| <b>Application Ref:</b>            | 3/2026/0467 |                     |            | <br><b>Ribble Valley<br/>Borough Council</b><br><hr/> <a href="http://www.ribblevalley.gov.uk">www.ribblevalley.gov.uk</a> |
| <b>DELEGATED ITEM FILE REPORT:</b> |             |                     |            | <b>APPROVAL</b>                                                                                                                                                                                               |

| <b>Development Description:</b> | Proposed dormer loft conversion to include the extension of the existing flat roof dormer to the rear, alteration of the existing front dormer to a pitched roof, additional pitched roof dormer to the front elevation, installation of conservation rooflights, alterations to external window and door positions including a Juliet balcony and associated internal alterations. |
| <b>Site Address/Location:</b>   | Shire Croft Shire Lane Hurst Green BB7 9QR

PROPOSED NORTH ELEVATION
Scale 1:100

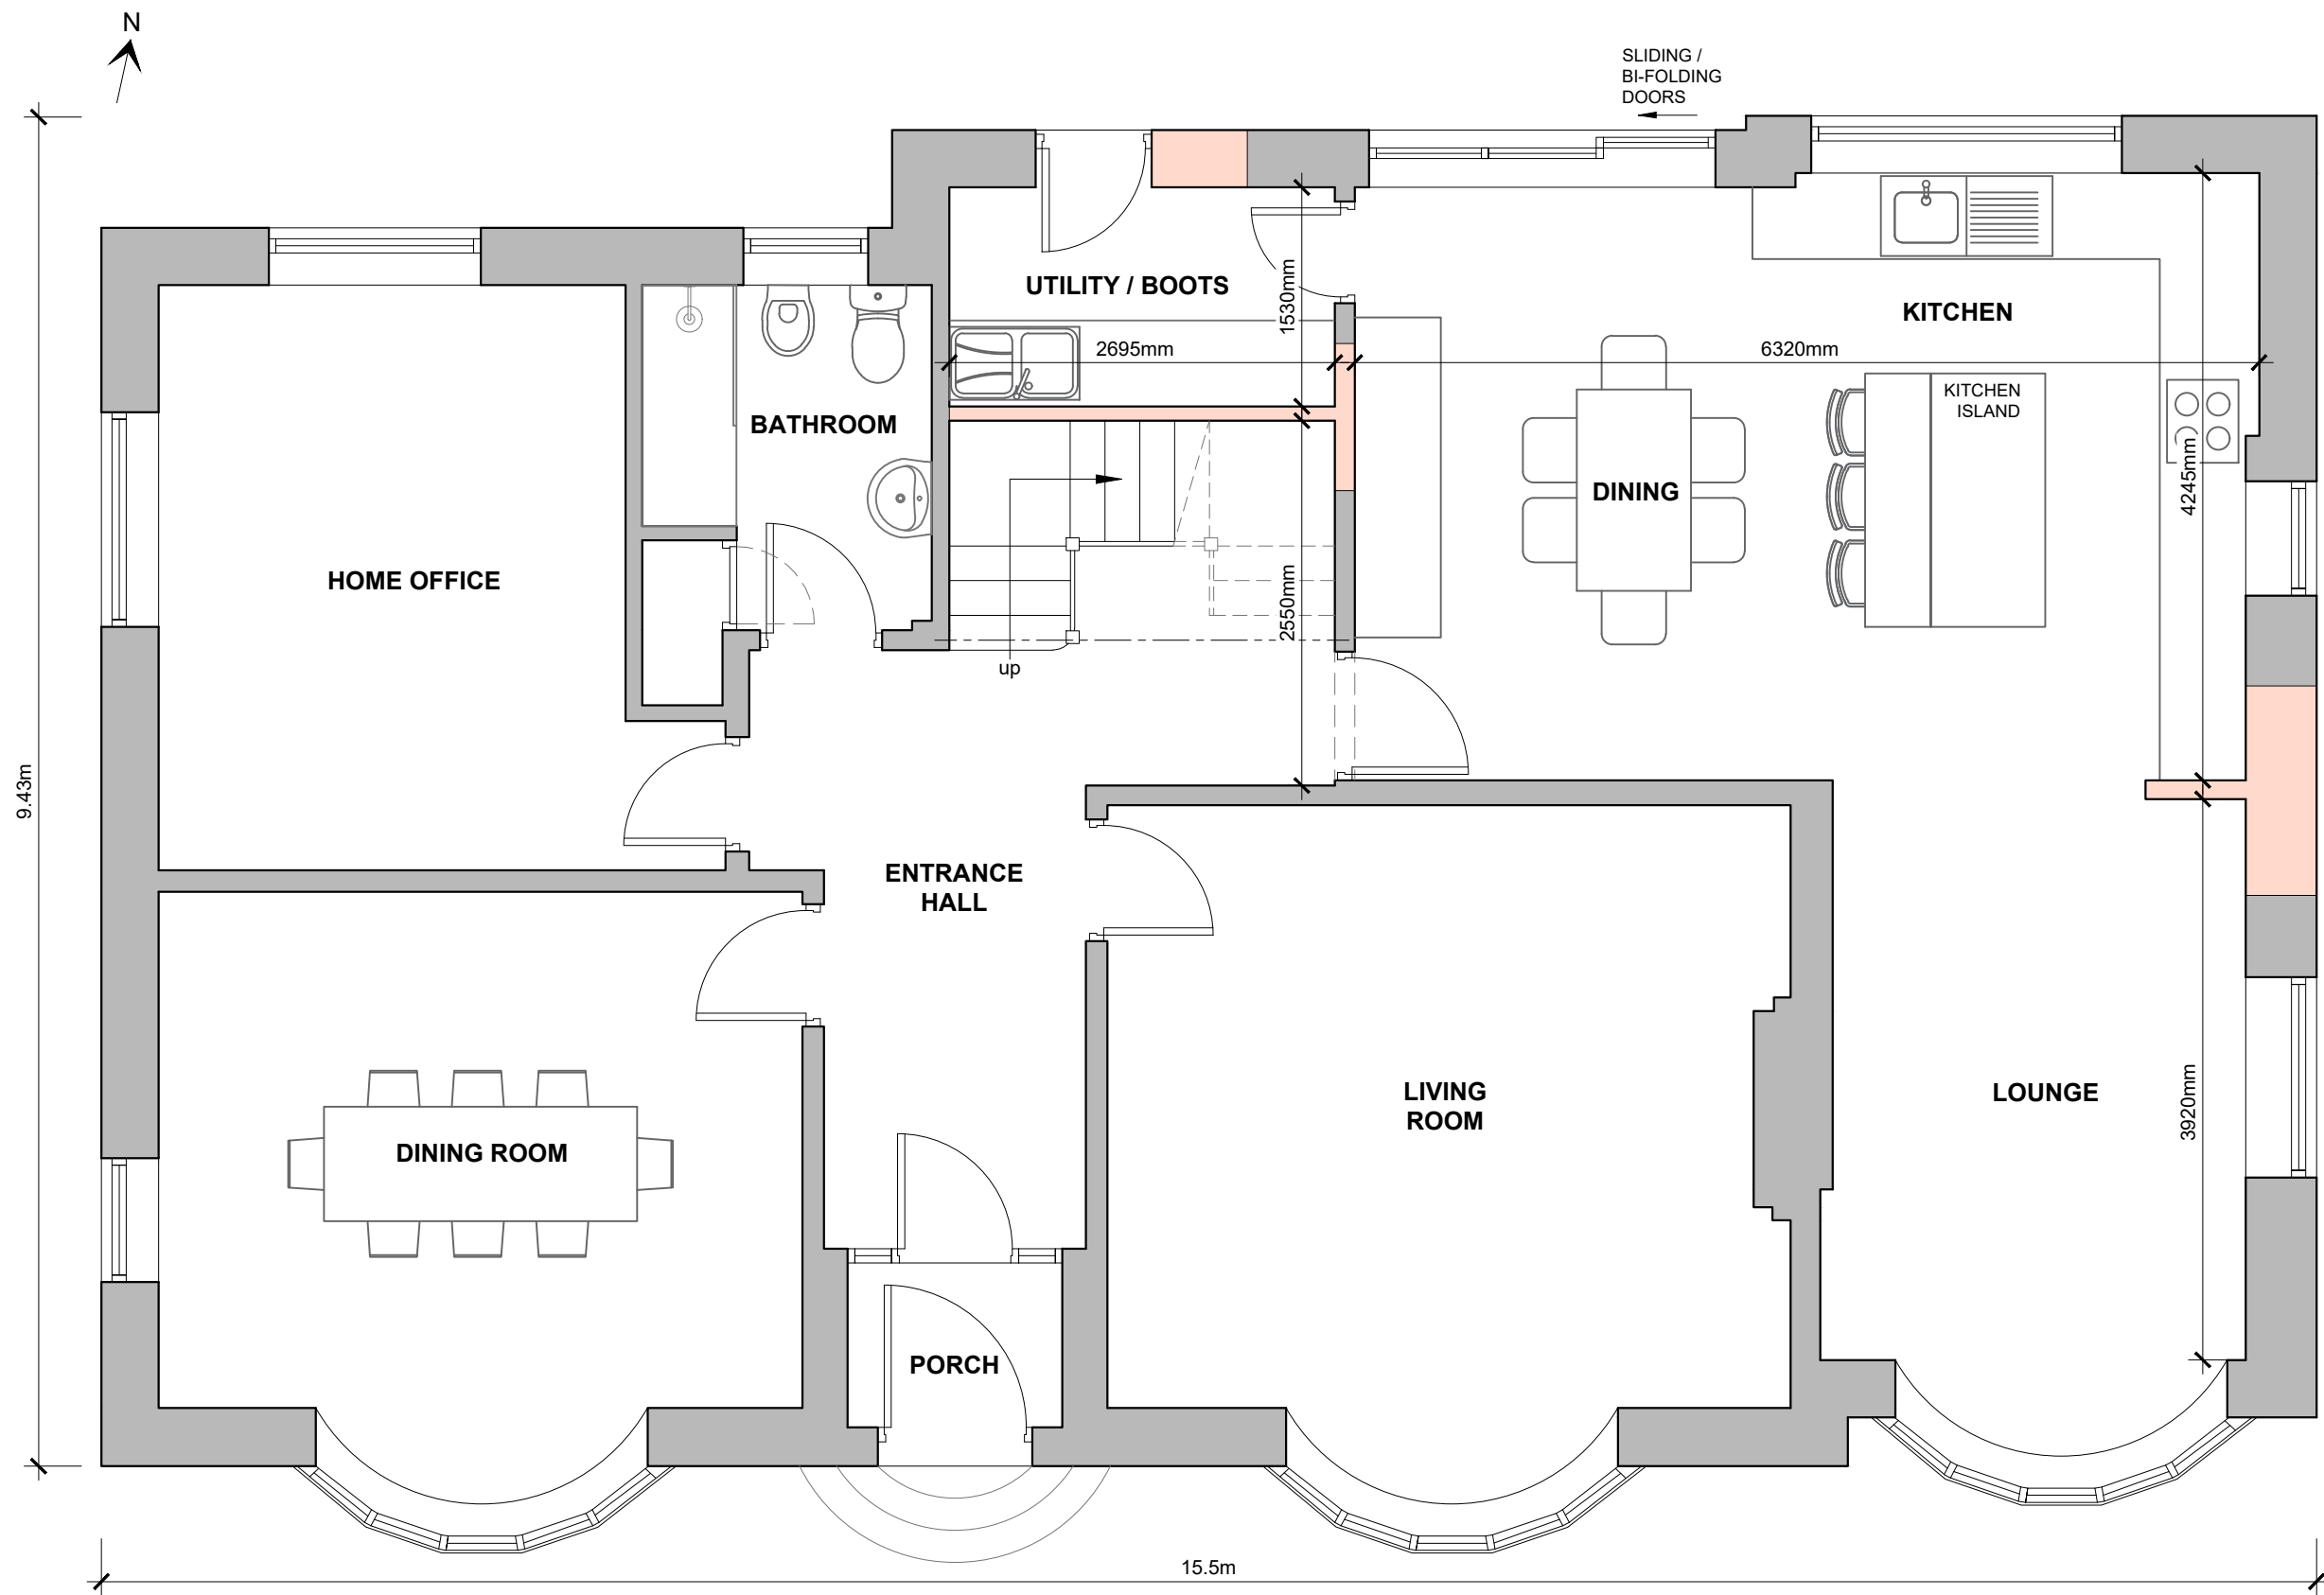
- The proposed Juliet balcony on the western side elevation has been removed
- The proposed dormer extension to the northern rear elevation has been reduced in width and set in from the dwelling's edges

The initial proposal for a dormer loft conversion to the rear elevation featured a continuous form with an approximate width of 15 meters. It was determined that such a dormer would appear excessively dominant and incongruent with the rear roof slope. Consequently, the original proposal was considered contrary to Policies DMG1 and DMH5 of the Ribble Valley Core Strategy.

Subsequent amendments have been submitted, reducing the dormer’s width by setting it in 1.5 meters from each edge, yielding a total width of 12.55 meters. The amended dormer would be screened by the existing treeline and boundary treatment during the summer and spring months. Nonetheless, objections have been raised regarding the potential loss of screening in winter, which may increase the proposal’s visual

prominence. While this concern is acknowledged, the dormer would be located over 30 meters from the front elevations of Poole Cottage and The Haven; therefore, the proposal would not result in undue visual harm sufficient to warrant refusal. Furthermore, the proposed materials are consistent with the existing roof, further integrating the proposed development with the dwellinghouse and reducing its visual impact. As such, concerns regarding the scale of the proposed rear dormer have been addressed and it is now considered a sympathetic addition to the dwelling, in accordance with relevant planning policies.
